Recommendation Report for Planning Permission for Works or Extension to a Dwelling

REF NO: M/38/18/HH

LOCATION: 52 Silver Birch Drive
Middleton-On-Sea
PO22 6SJ

PROPOSAL: Single storey side extension & replacement of rear conservatory (resubmission following M/3/18/HH).

**GROUND FLOOR PLAN.
PROPOSED**

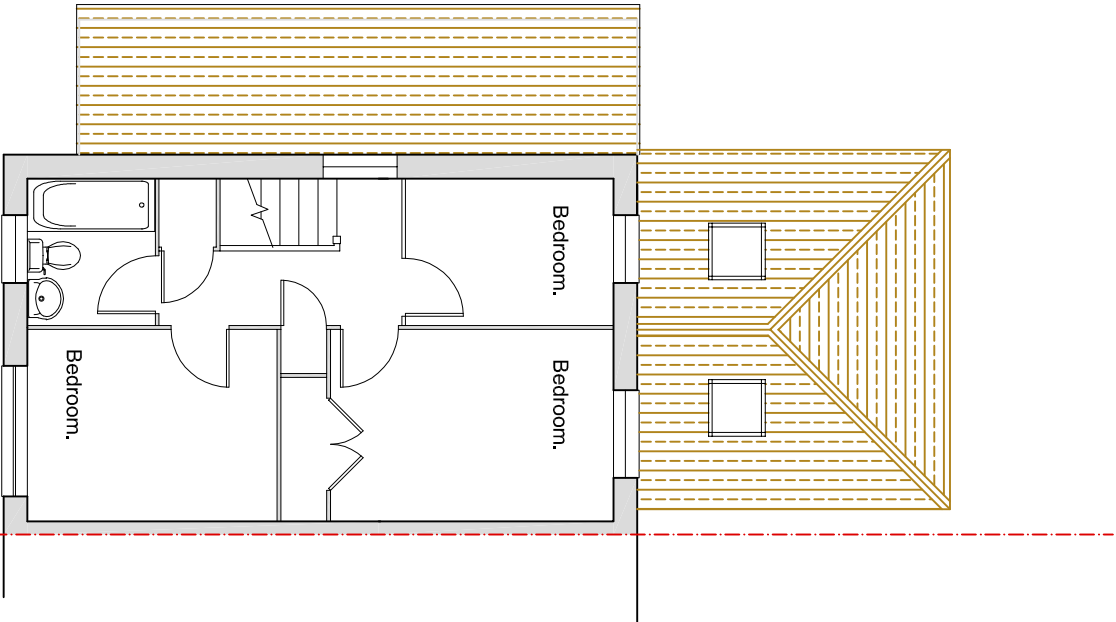
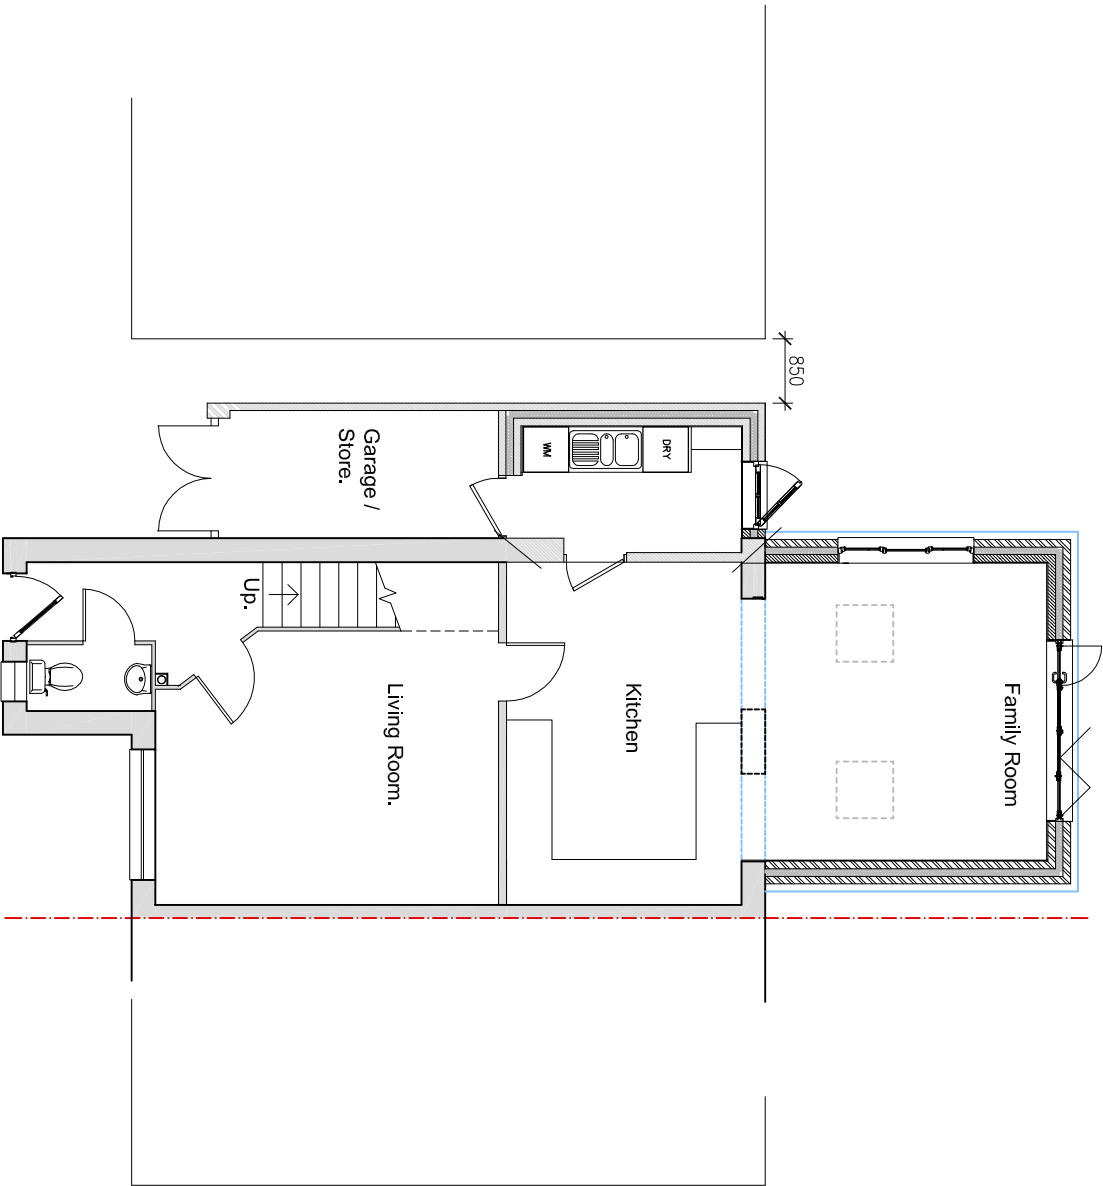
The proposals are for a modest single storey side extension and replacement rear single storey

extension retaining a gap of 0.85m at the side.

The proposed garage is only 1.6m wide - too small for a car but adequate for a motorbike and will not have a material effect on the appearance and character of the street scene.

The rear extension is of similar size to the existing occupying a similar footprint.

The design incorporates a fully hipped roof with rooflights on each roof slope.

The rear extension will have no material impact on the adjacent properties to either side.

The existing conservatory has glazing on 3 sides and a glazed roof so the proposal will result in a net reduction in the extent of glazing.

Block Plan

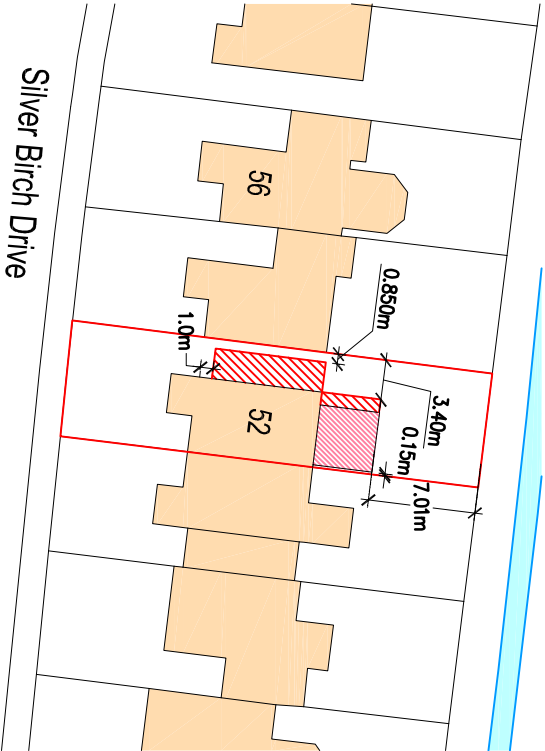
DESCRIPTION OF APPLICATION	As above
SITE CHARACTERISTICS	The application premises is a semi-detached dwelling with a small front projection and an existing rear conservatory There is an existing side space of 3.4m which will be reduced to 0.85m when the single storey side extension is built. The existing rear conservatory is to be demolished and replaced with a full width rear extension to be used as a family room
CHARACTER OF LOCALITY	The surrounding comprises mainly semi-detached dwellings along the north side of Silver Birch Drive. Most of the dwellings have a projecting section at the front with no side spaces. However No 52 retains a 3.4m wide side space which will be infilled by the proposed single storey side extension retaining a narrower gap of 0.85m
